Response to Planning application from Hertfordshire County Council (T and CP GDP Order 2015)

District ref: 6/2017/1662/ADV
HCC ref: WH/245/2017
HCC received: 10/10/2017
Area manager: Manjinder Sehmi
Case officer: Anthony Collier

Land behind and adjacent to 17 - 17A Station Road
Cuffley
Potters Bar
EN6 4HX

Retention of 8 x 2 m tall non-illuminated freestanding banner advertisements

Block Plan shows area bounded by: 530475.93, 202676.07 530565.93, 202766.07 (at a scale of 1:500), OSGridRef: TL3052 272. The representation of a road, track or path is no evidence of a right of way. The representation of features as lines is no evidence of a property boundary.

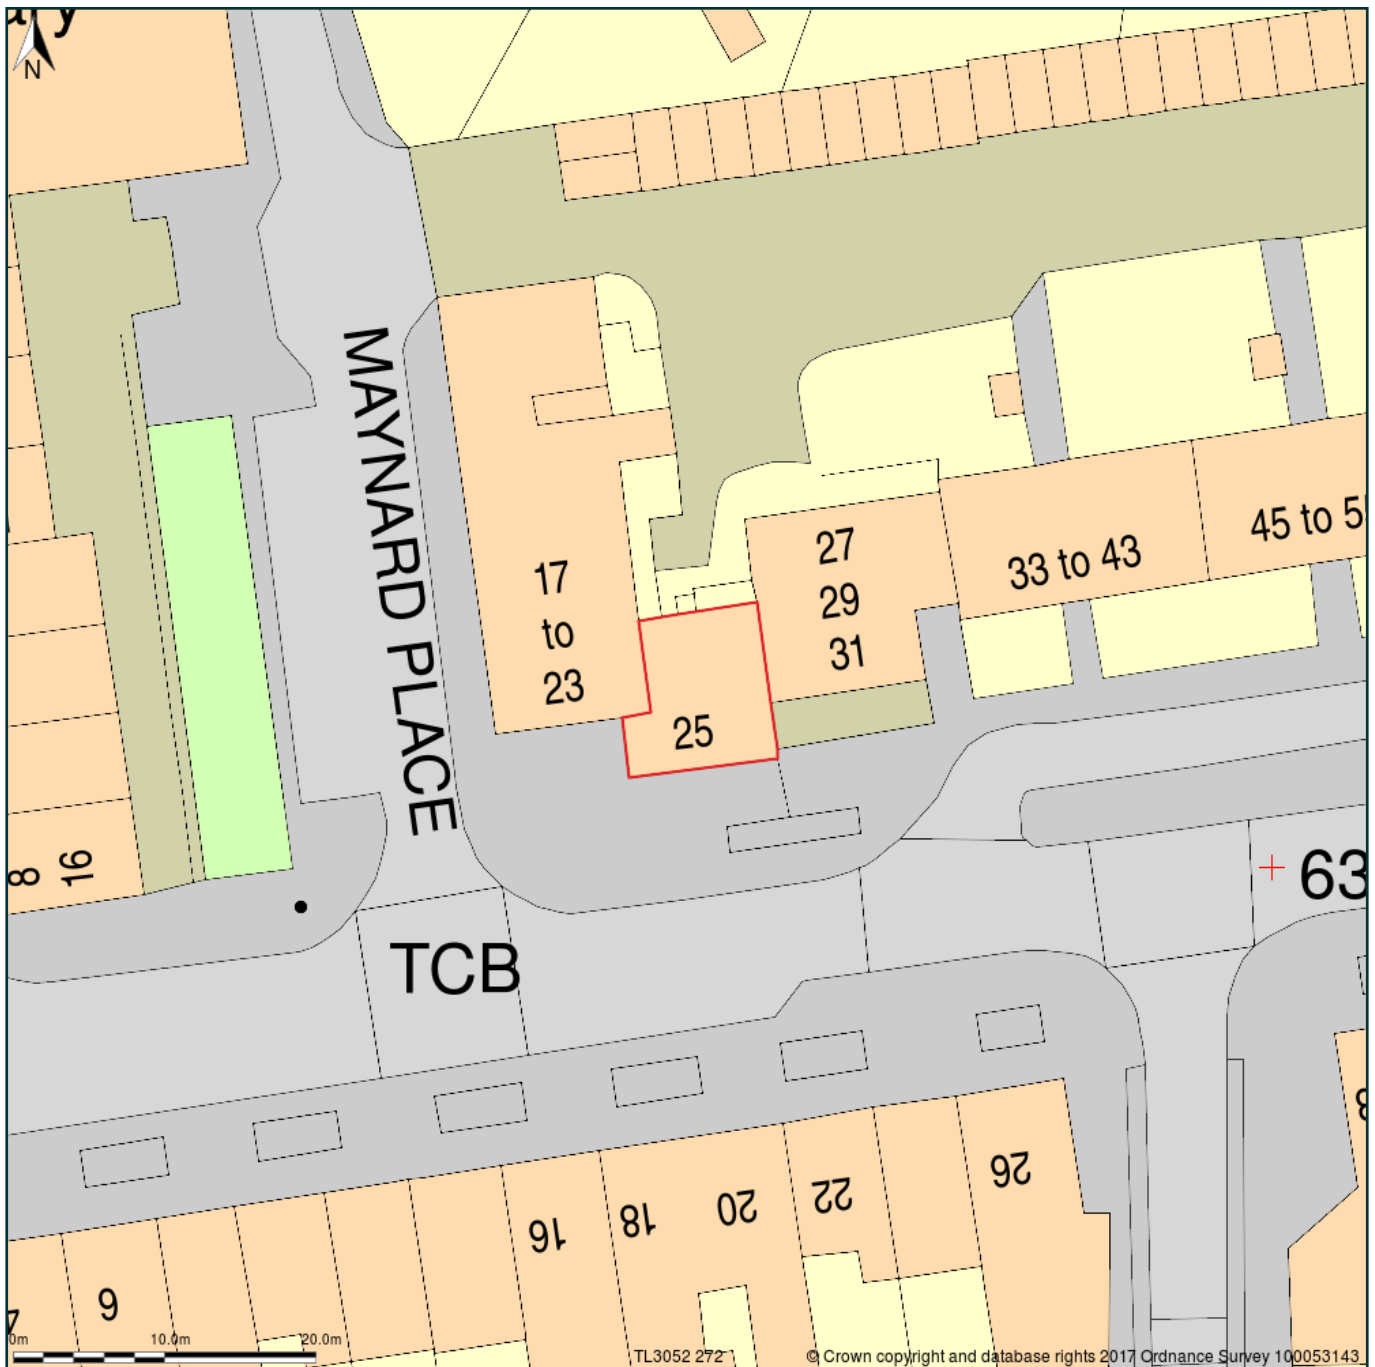
The proposed 'flags' are situated on ground not classified as having highway rights upon it. the footway is clearly delineated at the site and demonstrates where highway rights apply.

If at any point the moveable signs are placed within the public highway, they would constitute as structures within the highway and contravene the Highways act section 143 which would give the highway authority the authority to remove any structure.
